# M20 Junction 10a

TR010006

## Response to Kent County Council Submissions at Deadline 3

Volume 11.2  
February 2017

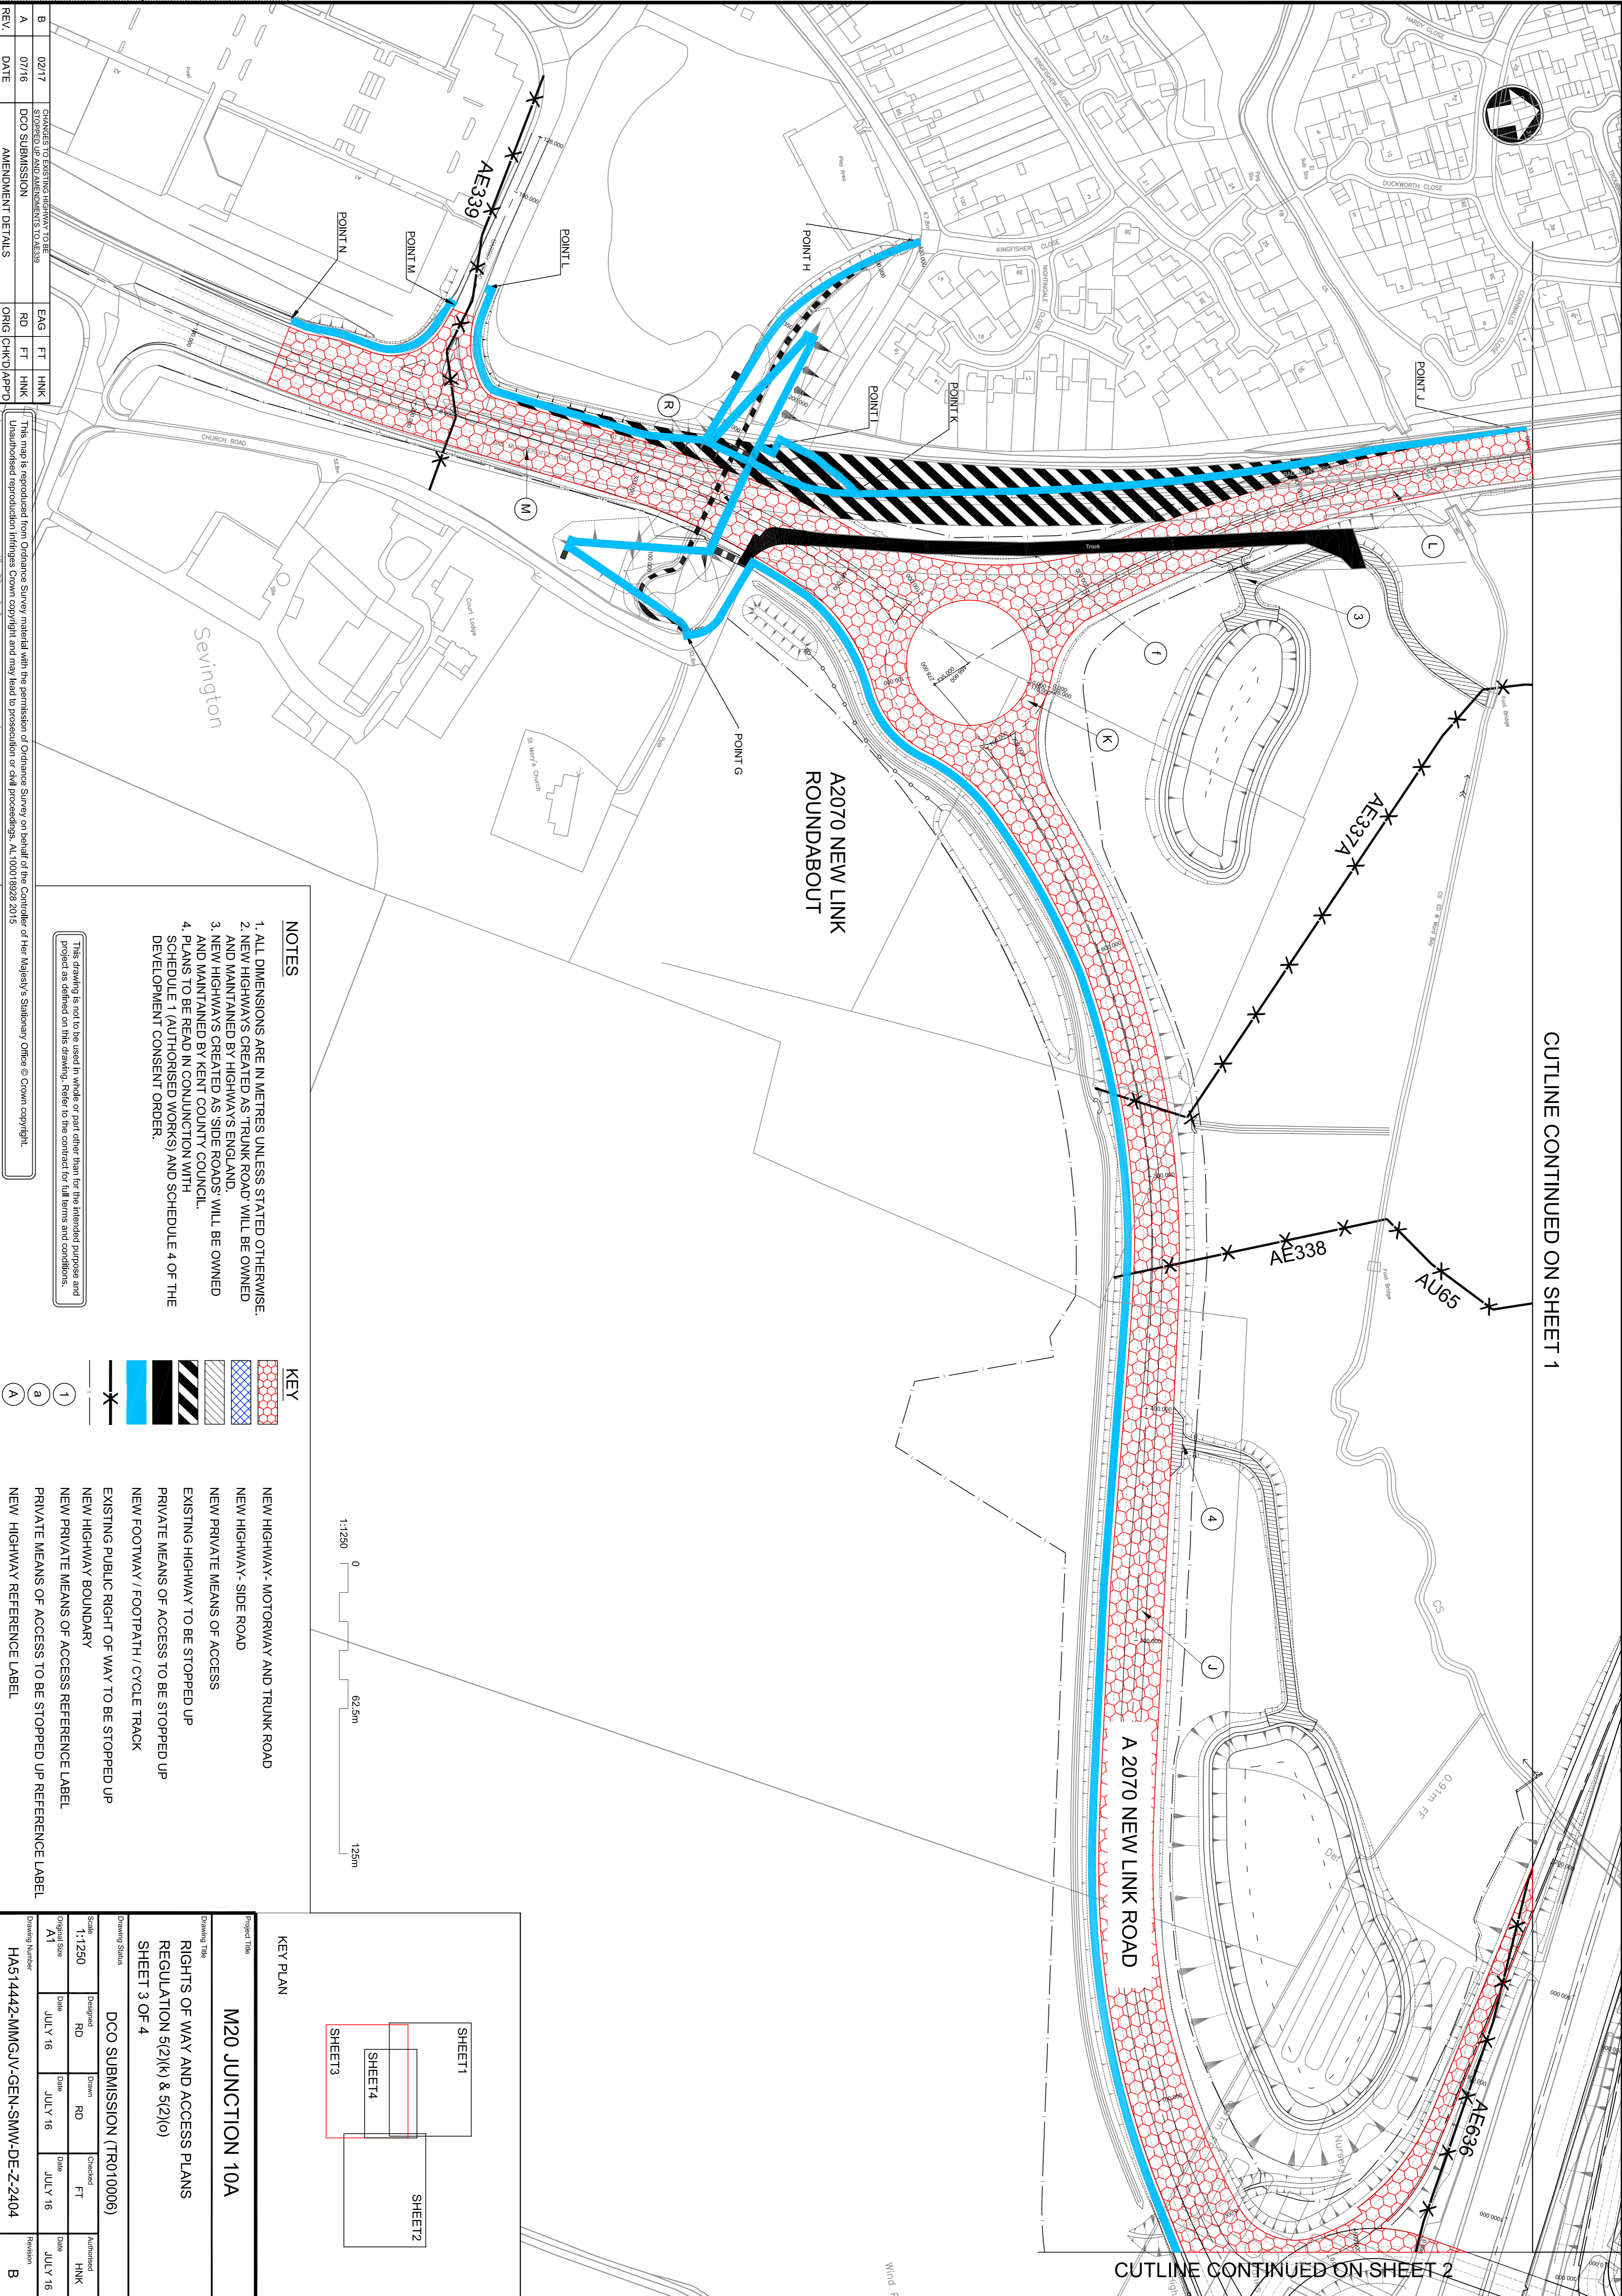
023.05	In relation to PRow – south side, KCC would expect drawings to show gaps in any drainage ditches/lagoons, to show that connections from the retained PRow are physically possible. This is a simple but necessary change, which KCC is not content has yet been adequately addressed.	PRow number AE338 and AE337A (located on the south side of the new A2070 Link Road) are located on the land owned and managed by the Friends Life, looking into their planning application 14/00906/AS new building (Plot 6) is proposed in this location. The stopping up or re-directing of those two footways should be managed by Friends Life.
